From: Amanda Scholes on behalf of Planning.Responses
Sent: 18 July 2018 10:00
To: Planning Scanning
Subject: FW: BR/143/18/PL

BR/143/18/PL

Change of use from vacant arcade (Sui Generis) to include A1 (Shops), A3 (Restaurant & Cafe) & A4 (Drinking Establishment) & outdoor seating area, change of ground floor external facade & installation of external bin store. This application affects the character & appearance of The Steyne Conservation Area

DRAWING TITLE	
Existing plans & Elevations incl. Site Location Plan	
DESIGNED BY	PH
DRAWN BY	Apr 18
SCALE	1:100, 1250

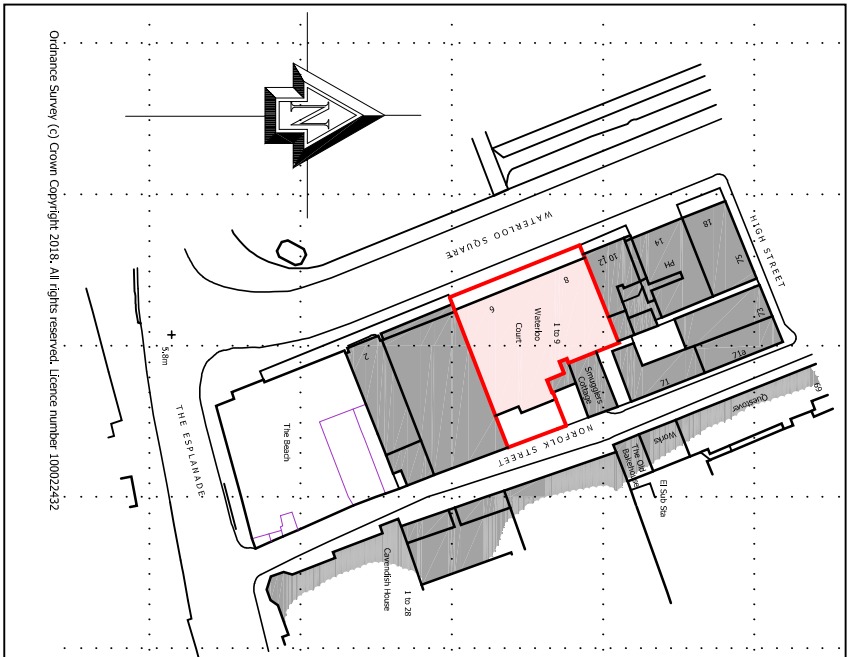
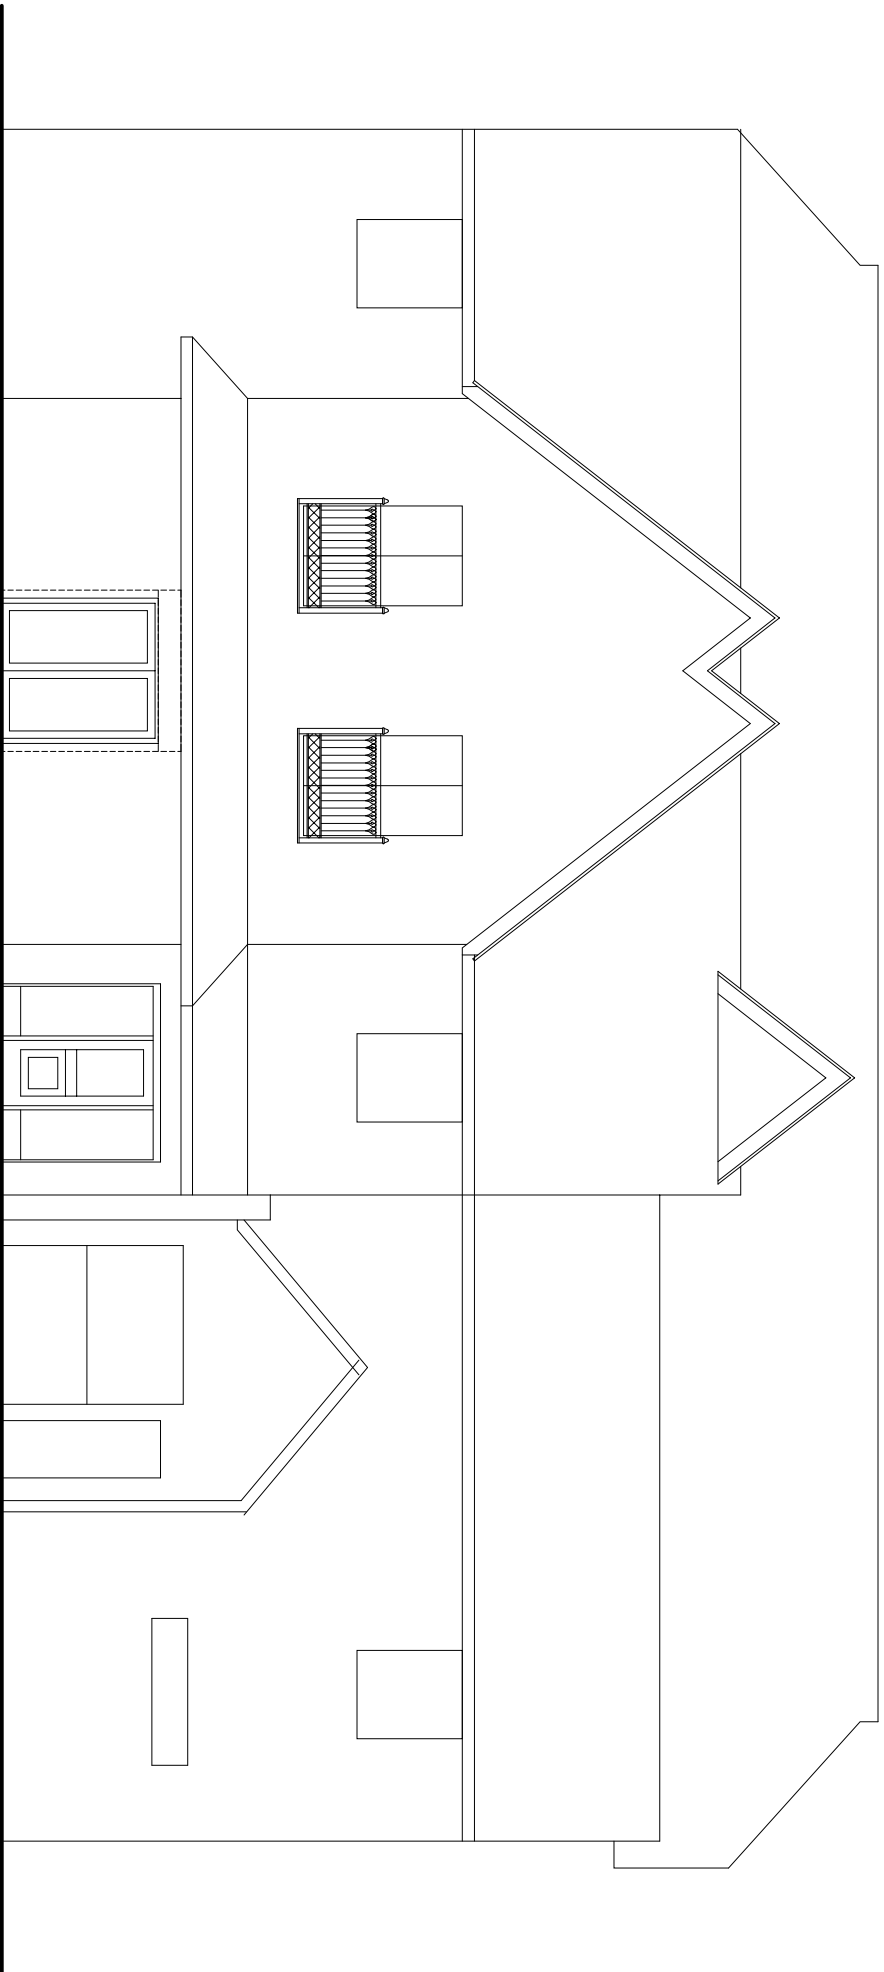
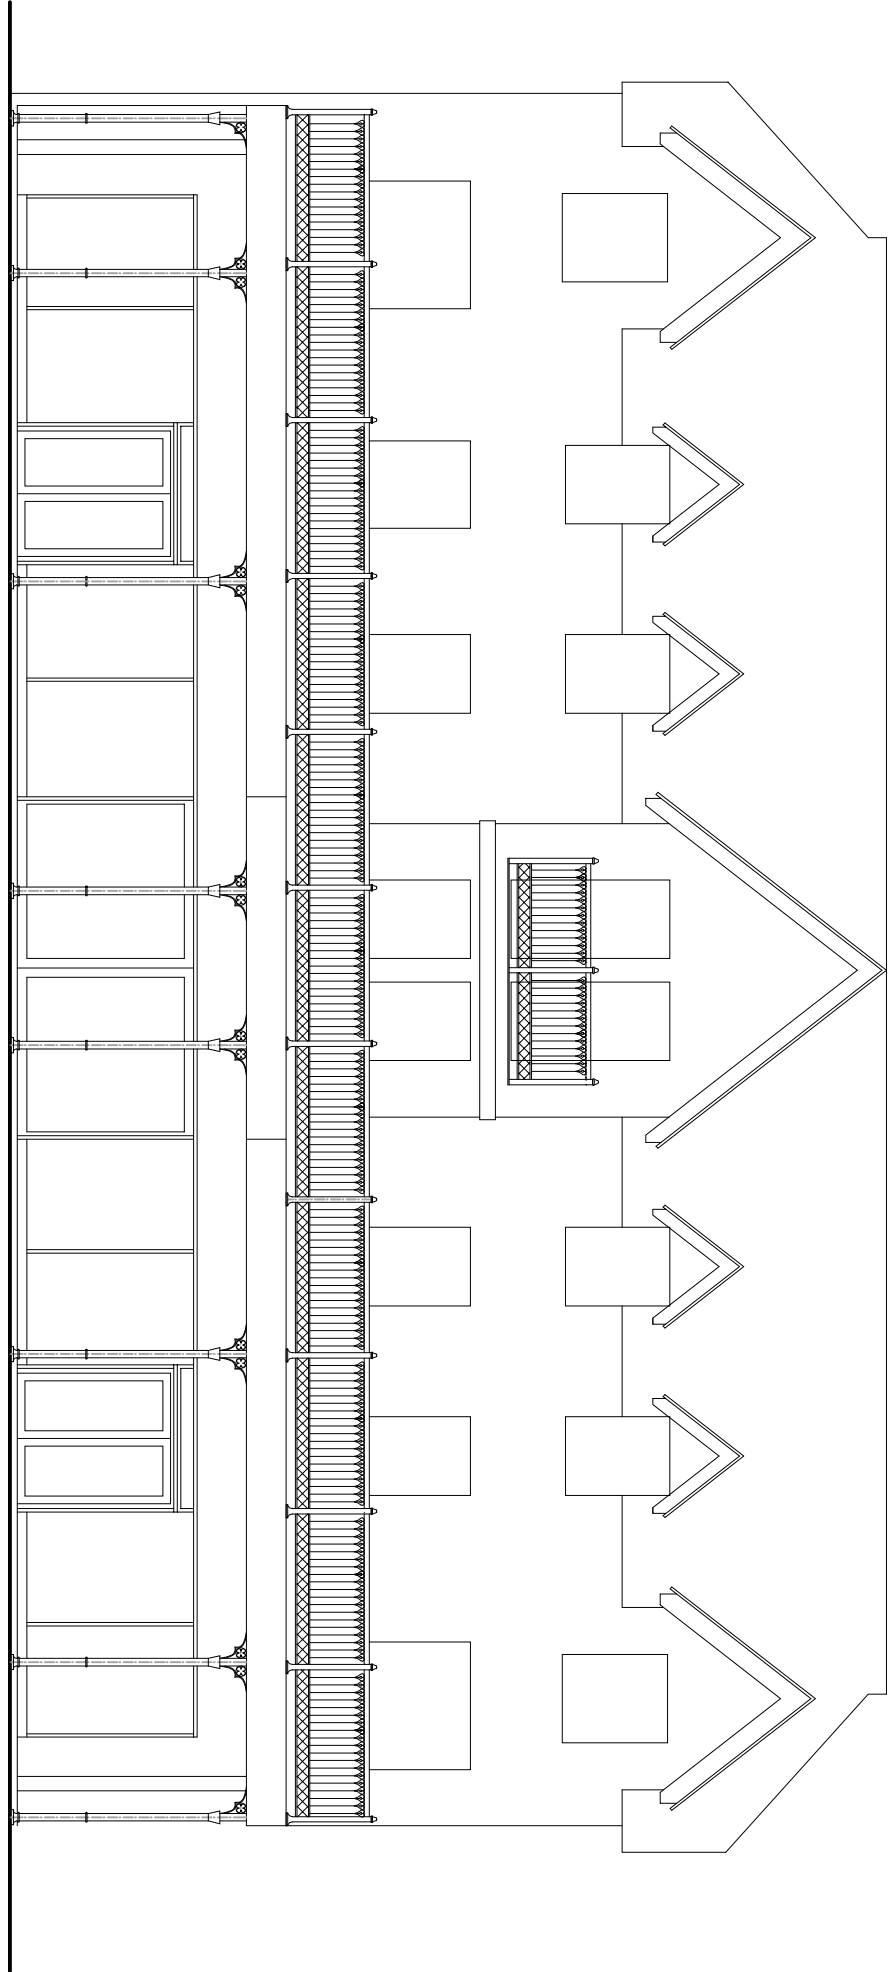
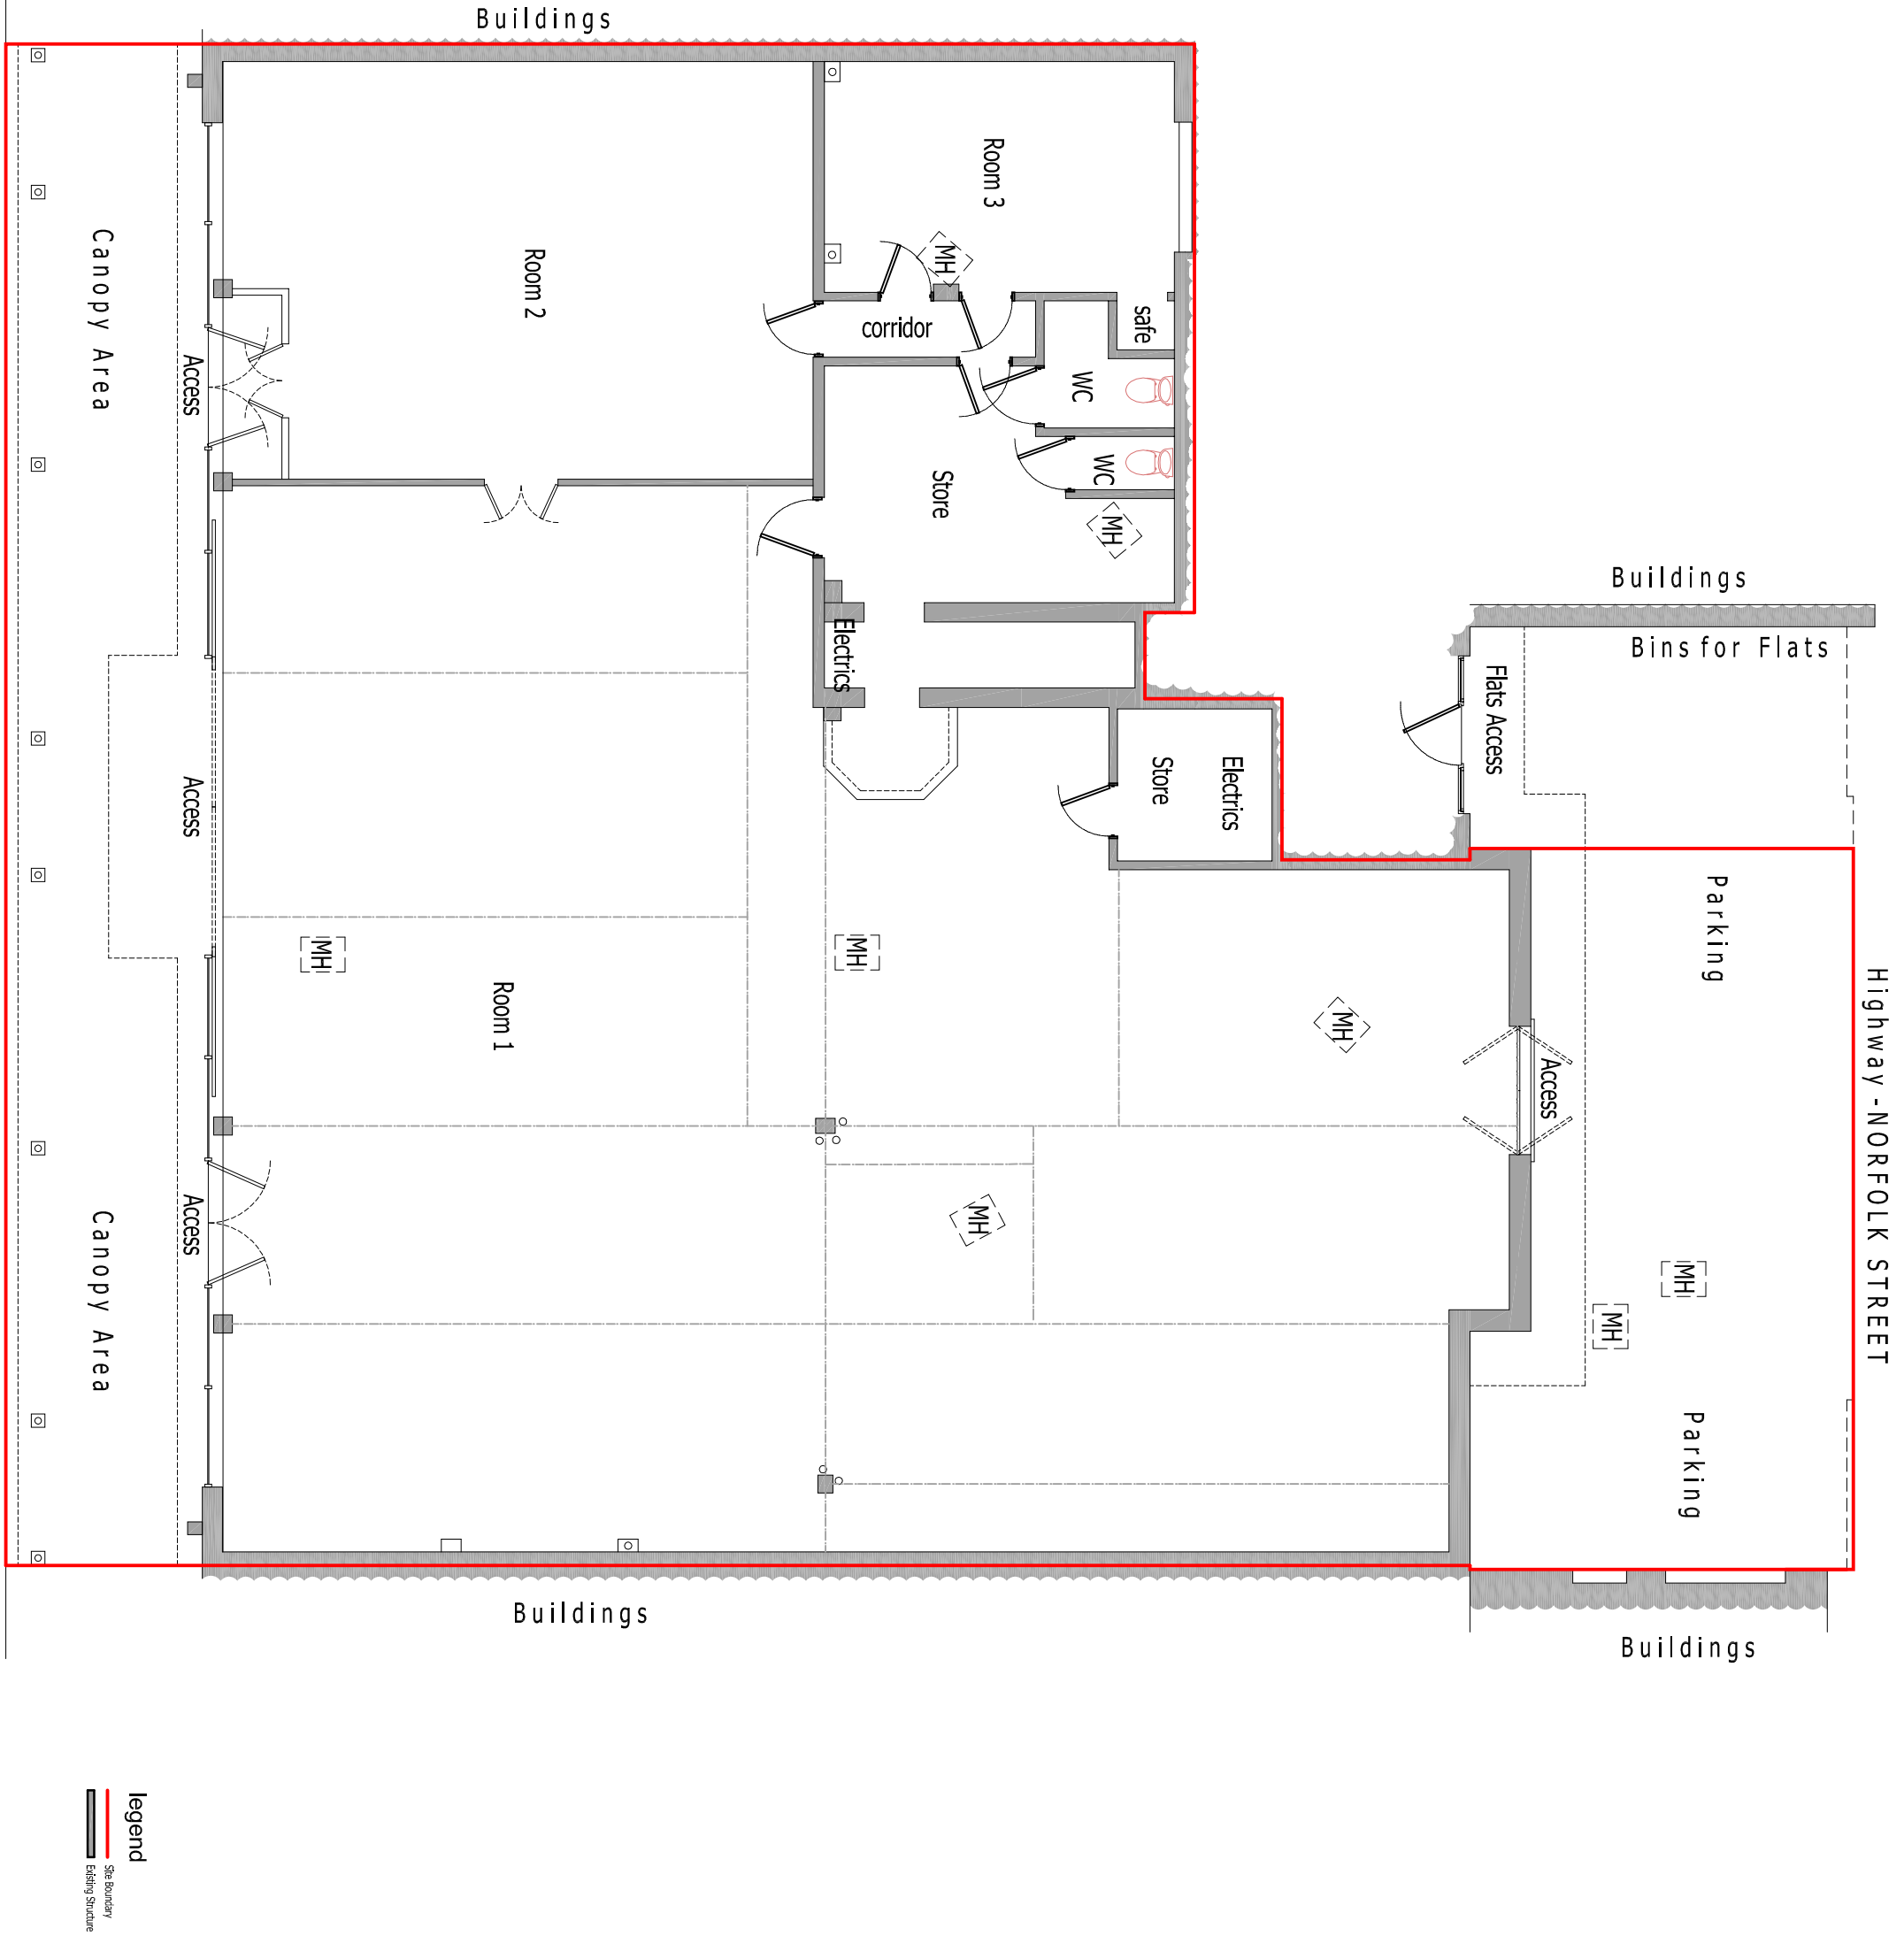
The current shop front is constructed from power coated aluminium in either dark grey or brown with full height bronze tinted glazing. This, along with the poor appearance of the shop front means that it detracts from the character and appearance of the Conservation Area.

The proposal to replace the existing inappropriate shop front with something that is much more in keeping with a conservation area will have a positive impact. It is considered that details of the final design and the proposed colours should be provided to the Council by way of condition.

Repainting of existing canopy, support posts and timber fascia is also supported, provided that the colours etc. can be agreed with the Council.

If minded to approve this application, please condition materials and colours to be agreed with the Council.
